Lindisfarne,
Babsham Lane,
Bognor Regis.
West Sussex.
PO21 5EL

Planning Application: BE/89/19/PL
Change of use of land at Babsham Farm

PROPOSED SITE PLAN - 1:200

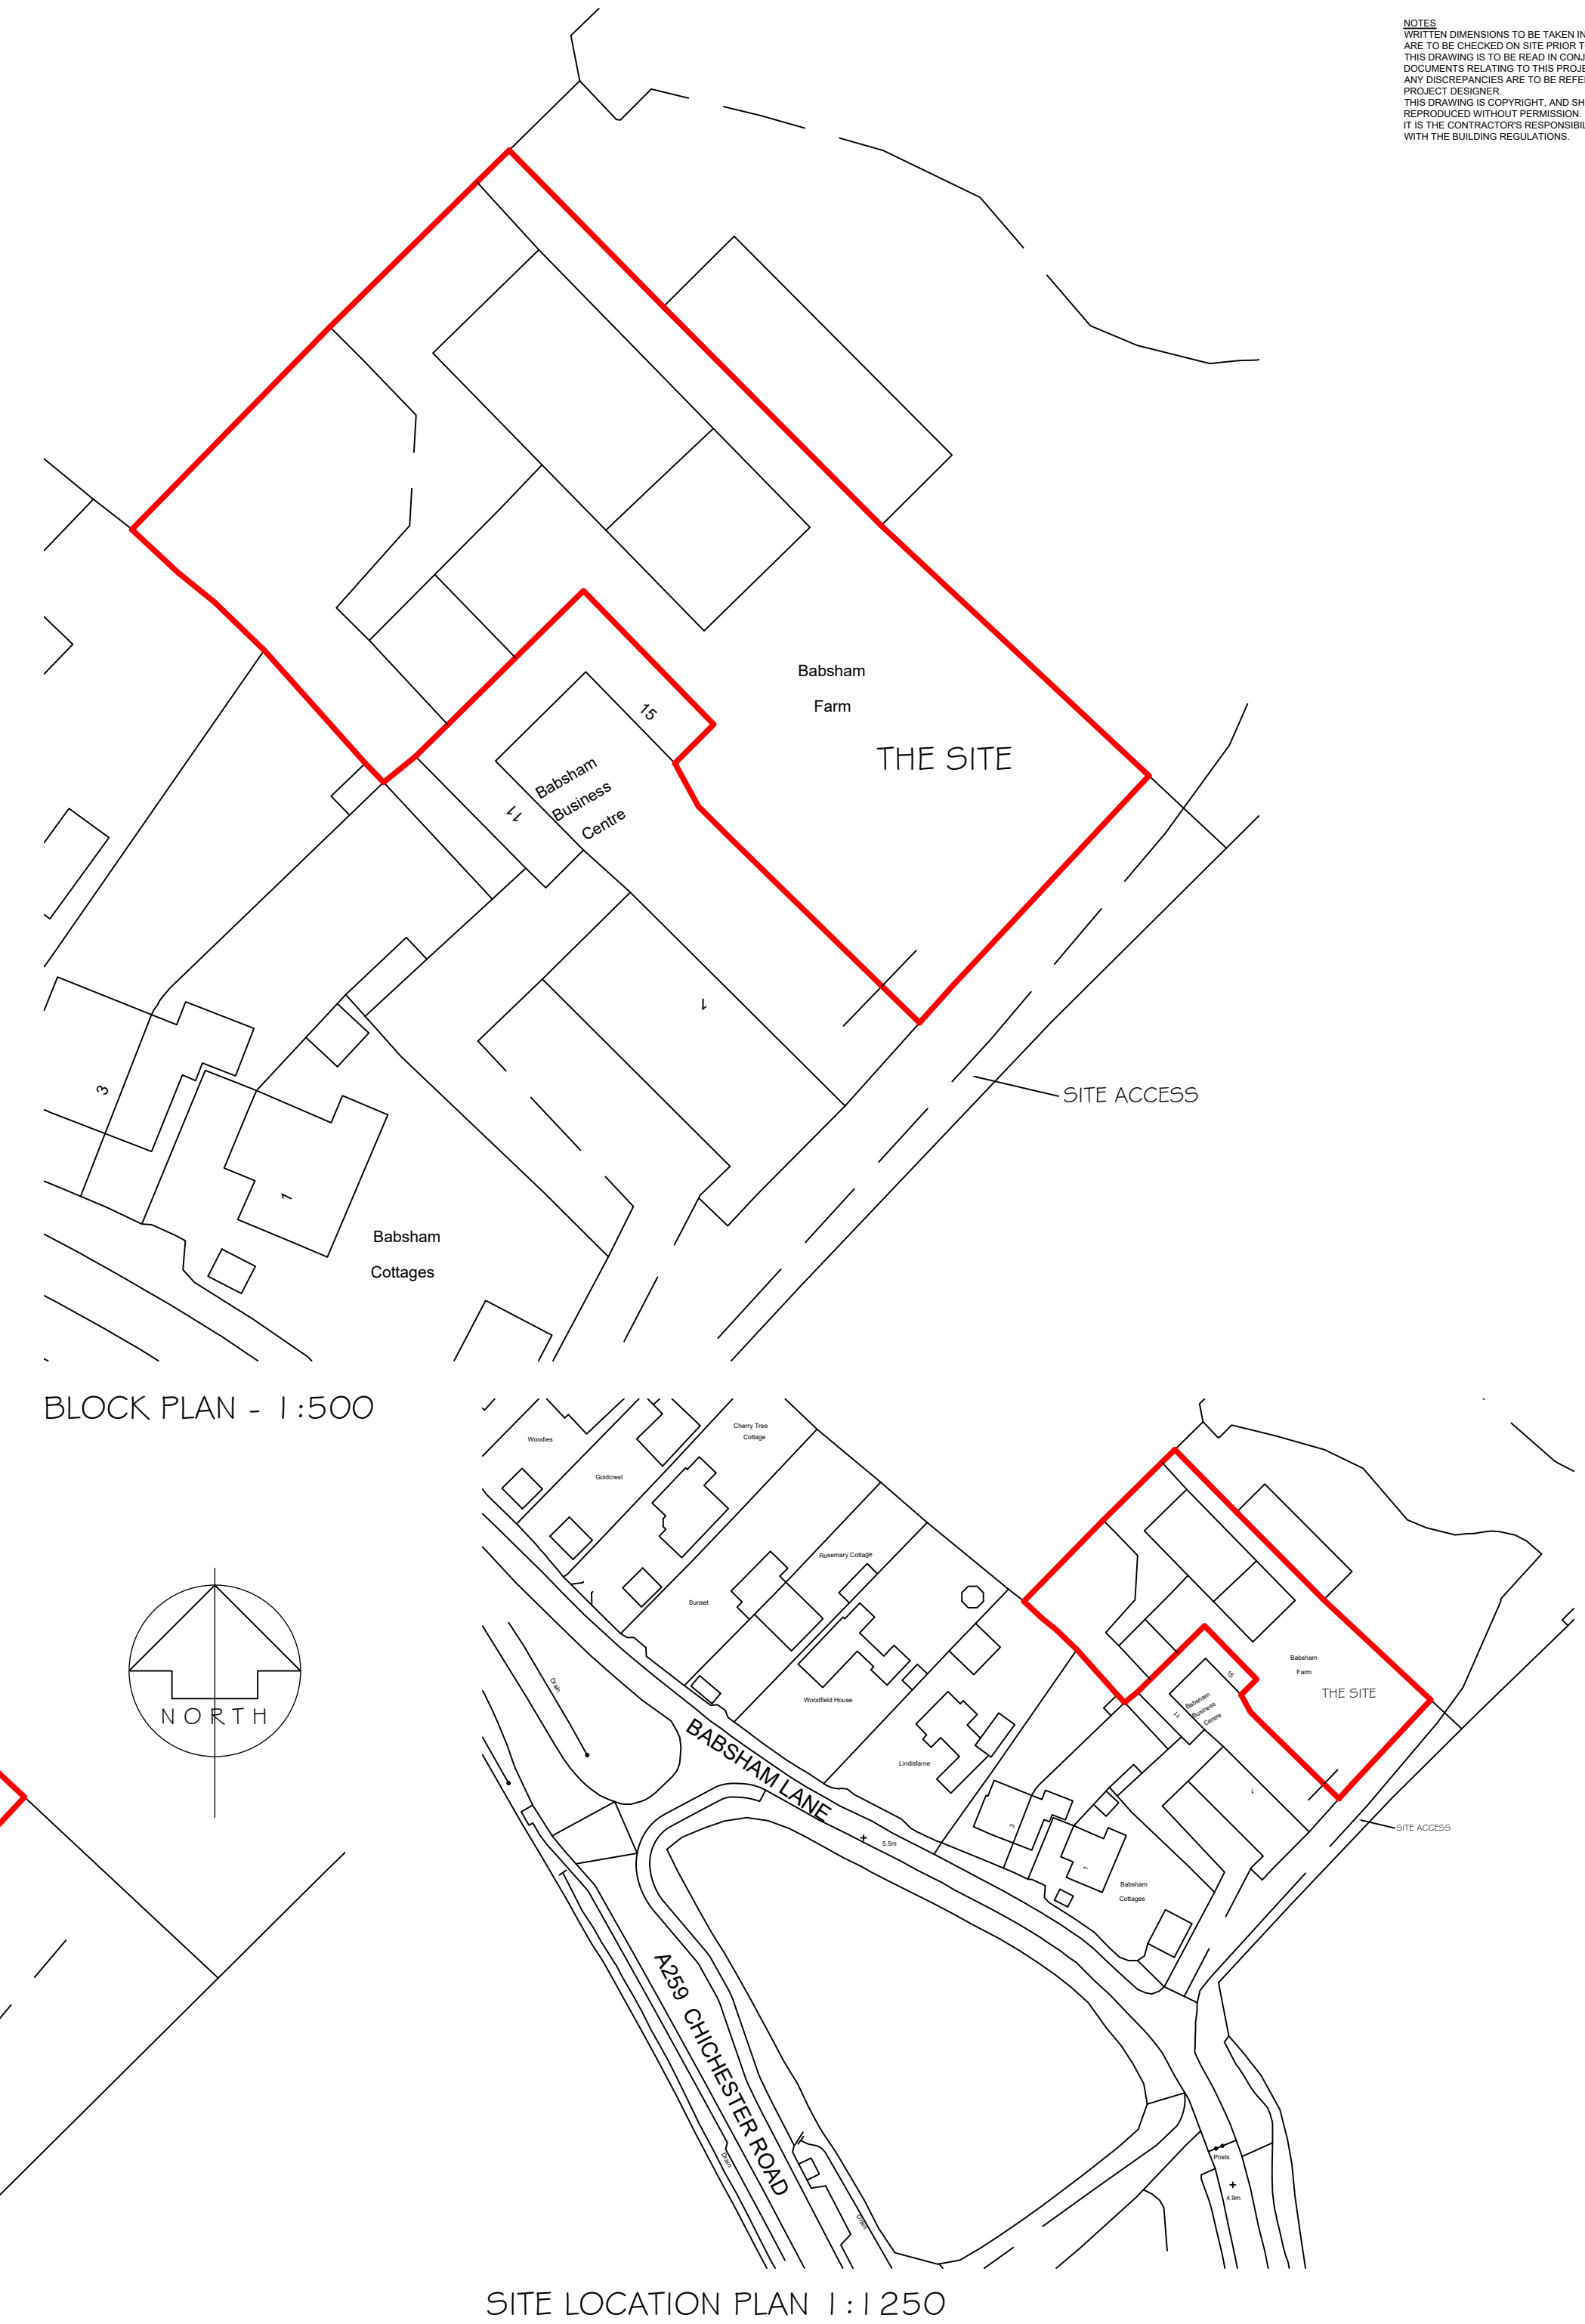
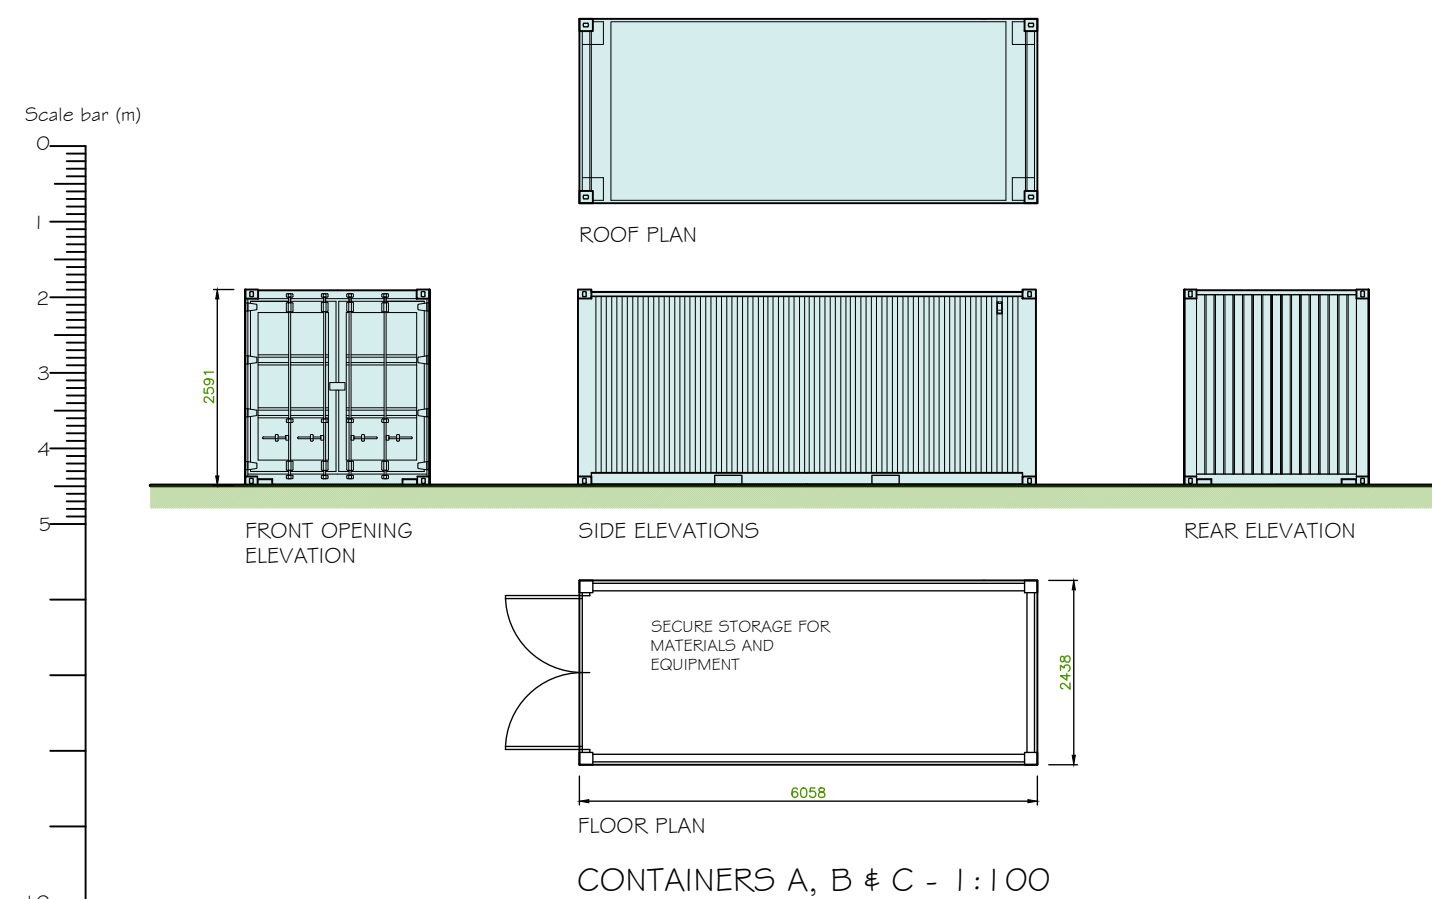
The plan includes the erection of a 2.4m close boarded screen fence on the SW boundary of the site immediately adjacent to an existing 1.7m brick wall which runs along the NE boundary of our property. According to the plan, an area of existing vegetation directly beyond our boundary wall is to be 'retained' and it is our contention that the proposed fencing would serve no useful purpose but rather, to the contrary, would impact in a negative way on this property and the other properties which back on to the SW boundary of the site.

It would be our hope that were a Planning Officer to make a visit so that this reasonable concern could be demonstrated, the applicant might be advised to withdraw this feature of the plan.
